Northumberland County Council's responses to the Examining Authority issues and questions issued on 19 November 2020 – ExQ1

Drawing Title: RIGHTS OF WAY AND ACCESS PLANS REGULATIONS 5(2)(k) & 5(2)(o) SHEET 04 OF 19

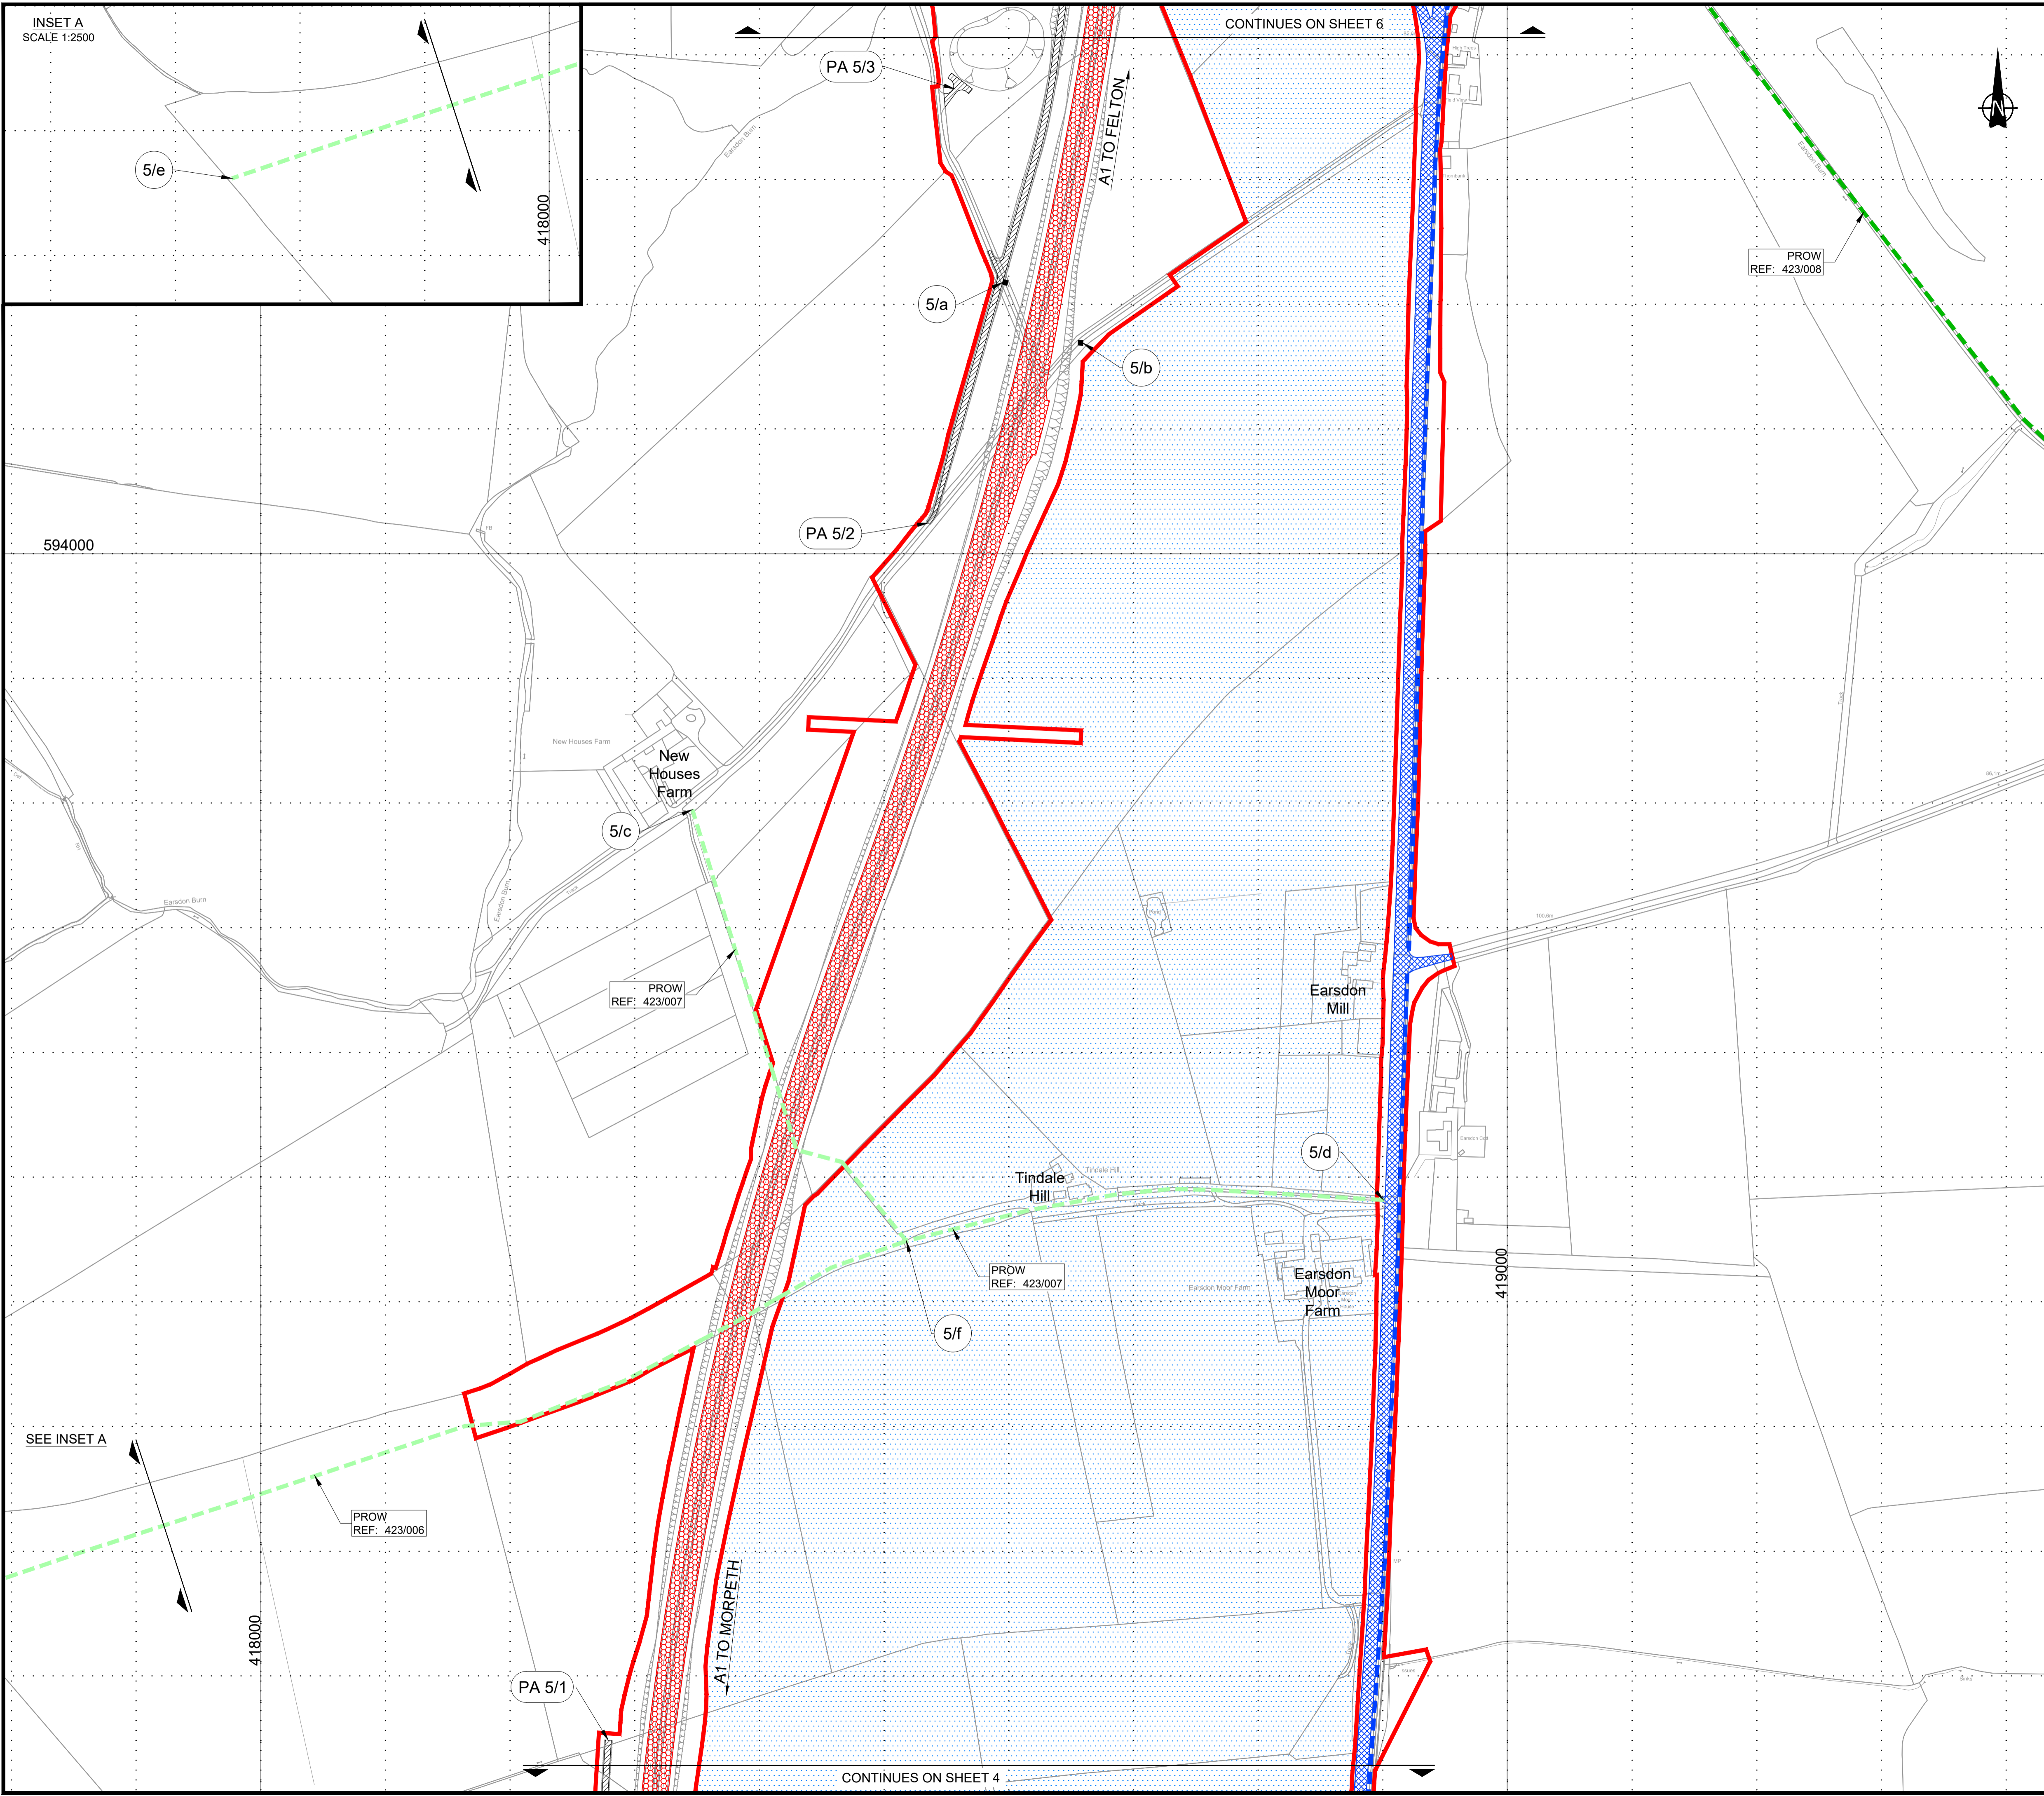
<p>The principles set out within Article 16 are generally agreed with however, clarification is required from the applicant in relation to the precise nature of the Stopping Up and the resultant status/ownership of the stopped up highway. For example on Sheet 4 of the Rights of Way and Access Plans (APP-009) there are sections of highway that are to be Stopped Up but would form part of the “future” Highway verge or would be isolated areas of “private” land enclosed by current/future Highway.</p> <p>We would additionally comment that it would provide greater clarity in Schedule 4 Part 1 for specific road classification numbers (including C and U classified roads) to be used, including in the replacement sections of highway. It is also noted that a distance is not specified on the second entry in Schedule 4 Part 1 in relation to the extent of the permanent stopping up and removal of the existing A1 carriageway starting at 3/d.</p> <p>The road classification numbers have been sent to the applicant’s consultant WSP via e-mail on 17 December 2020 and these are appended to these questions as Appendix NCC04.</p> <p>The tables appended to this document labelled NCC005 replicates the relevant parts of Article 16 as it affects public rights of way. We have proposed for consideration new text which better reflects the proposed changes to the rights of way network and is in a format which is common to work associated with the stopping up and diversion of public rights of way through statutory procedure. The new text also incorporates changes to the</p>

Plan 4 (see attached annotated plan)
